Snowy 2.0 - Exploratory Works - Modification 2 - Tunnelling methodology (SSI-9208-Mod-2) (Snowy Monaro Regional, Snowy Valleys)

I refer to the above matter that was distributed to the Department of Primary Industries (DPI) for comment on 5 November 2019.

Figure 2-6 Indicative location for subaqueous rock placement in Talbingo Reservoir

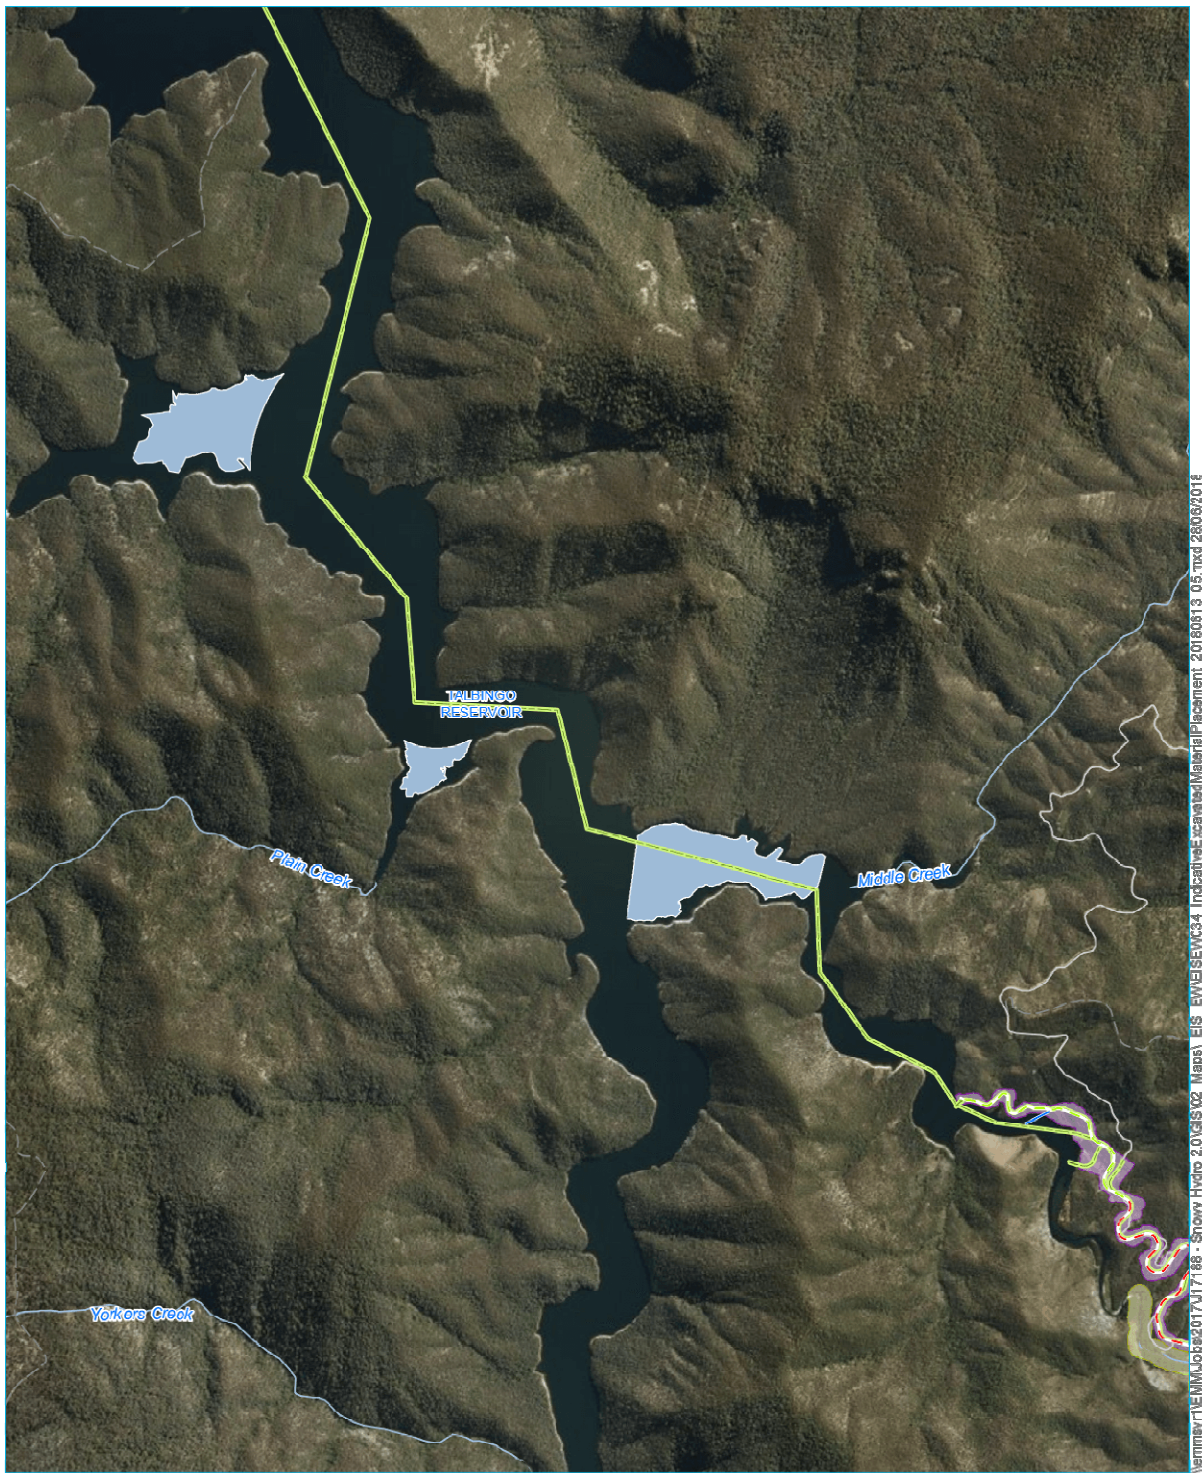
The Modification 2 Assessment Report does not include any details on the management of the spoil that is to be produced from the tunnel boring machine (TBM) for the exploratory works tunnel, DPI has concerns regarding the disposal of this material and potential impacts on water quality and the aquatic ecosystem.

The approval granted for the exploratory works includes a trial disposal of the spoil material from the exploratory tunnel, however this approval and the assessment behind it was developed around spoil produced from drill and blast operations rather than TBM. DPI objects to the subaqueous disposal of any TBM material from the exploratory works without further assessment regarding the impacts of the subaqueous disposal of such mater and the potential impact on water quality, aquatic species particularly Murray Crayfish.
